Application for a non-material amendment following a grant of planning permission.
Town and Country Planning Act 1990

House:	31	Suffix:	
House name:			
Street address:	North Lane		
Town/City:	RUSTINGTON		
Postcode:	BN16 3PL

Construction of single storey side & rear extensions to create open plan living areas & two additional bedrooms

Reposition the southern boundary wall further away from the boundary line.

1 | South Elevation
1:50

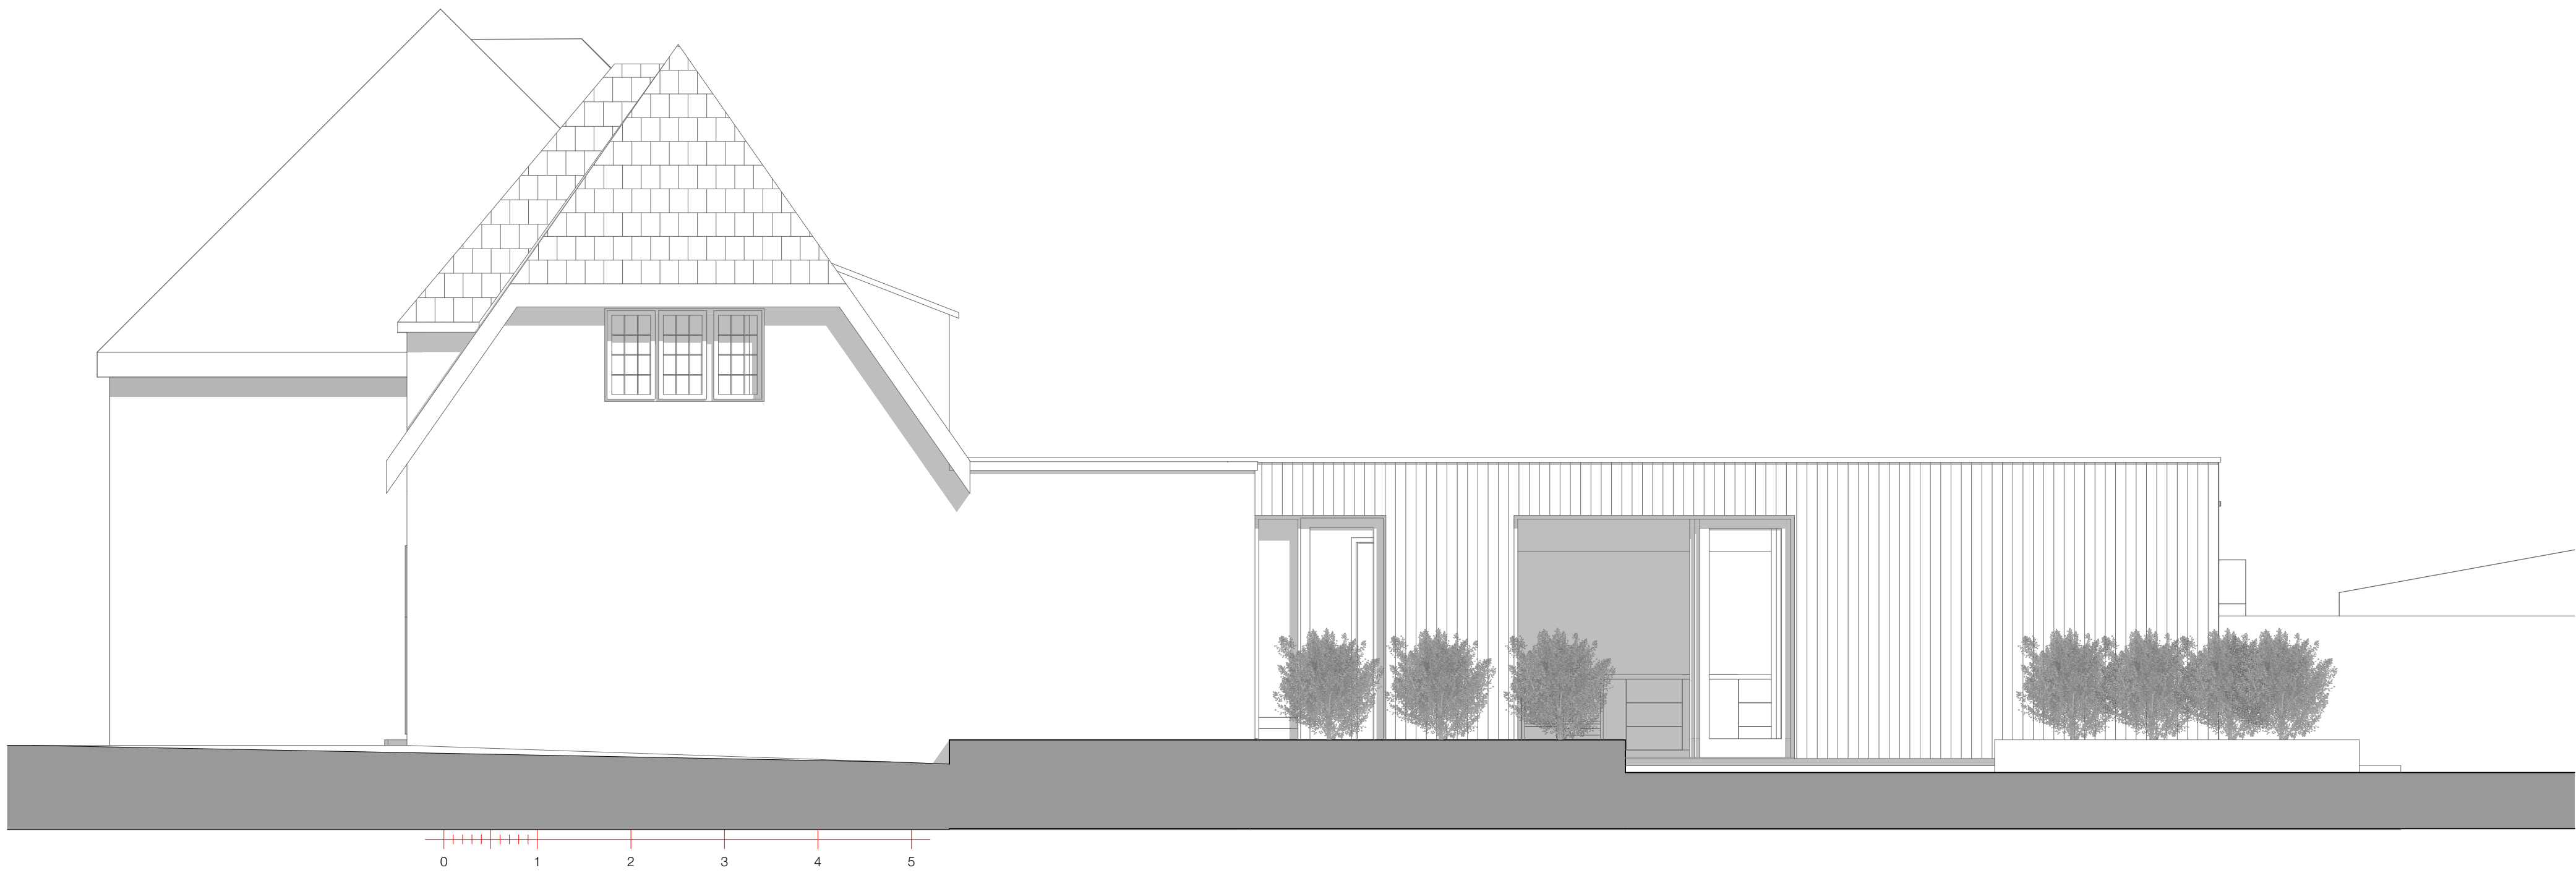
To create access for maintenance to boundary structures on No.29 North Lane

New plan/drawing numbers: 16 008 110 E 16 008 111 D 16 008 120 D
